CITY OF ALBUQUERQUE

May 16, 2019

Re: Kappa Office
124 Wellesley Dr. SE
30-Day Temporary Certificate of Occupancy
Transportation Development Final Inspection
Engineer's/Architect's Stamp dated 05-10-19 (K16D088)
Certification dated 05-10-2019

TRAFFIC CIRCULATION LAYOUT SITE PLAN (TCL)

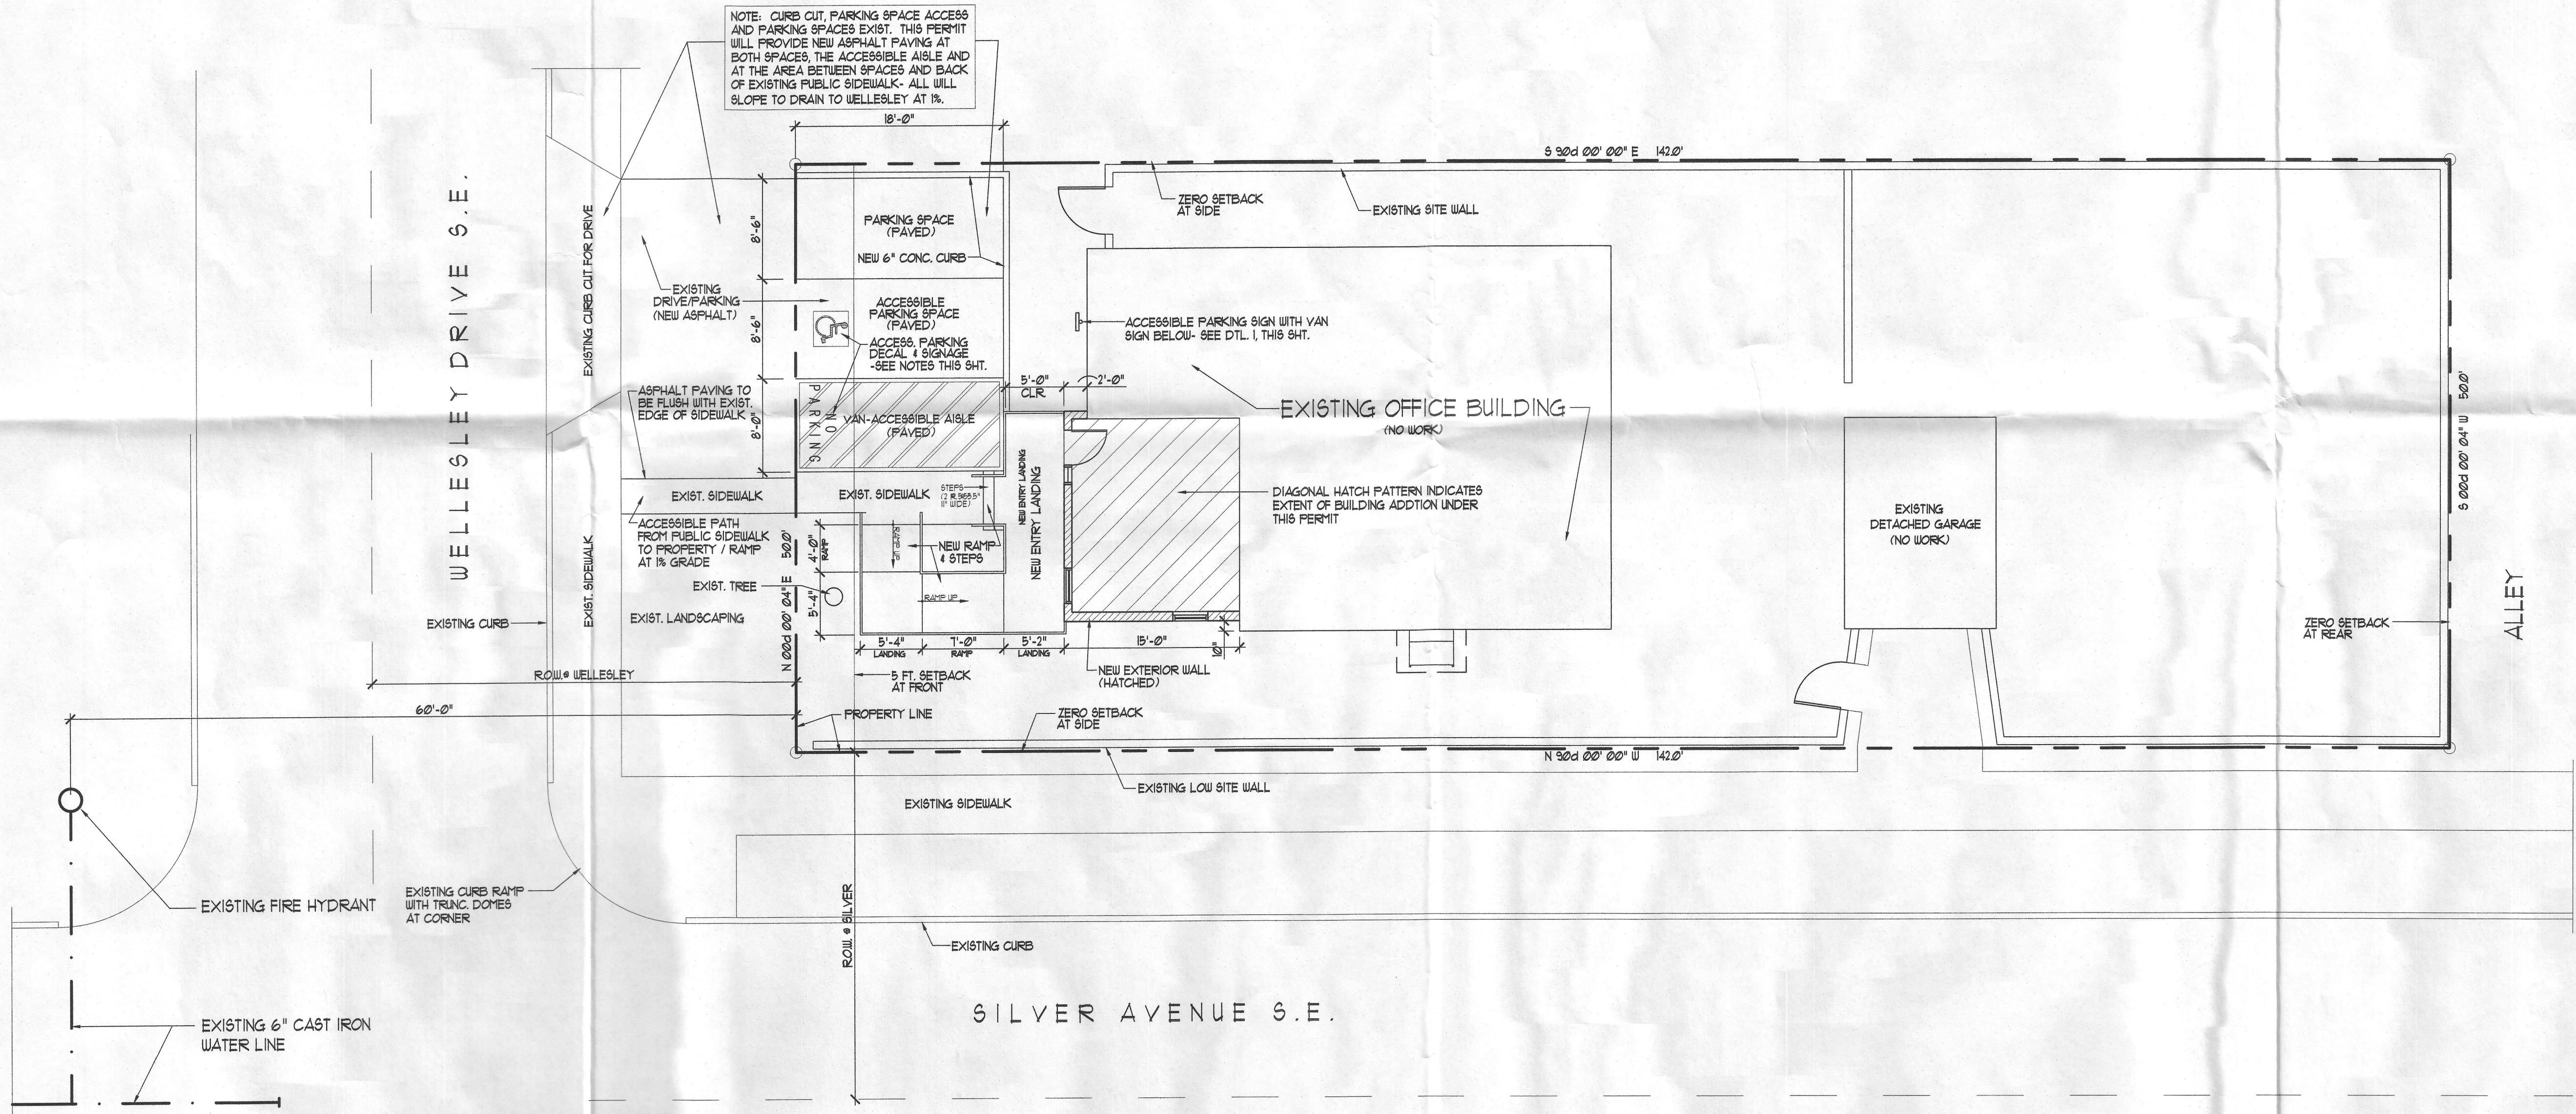
1. The "NO PARKING" marking is missing from the access isle.
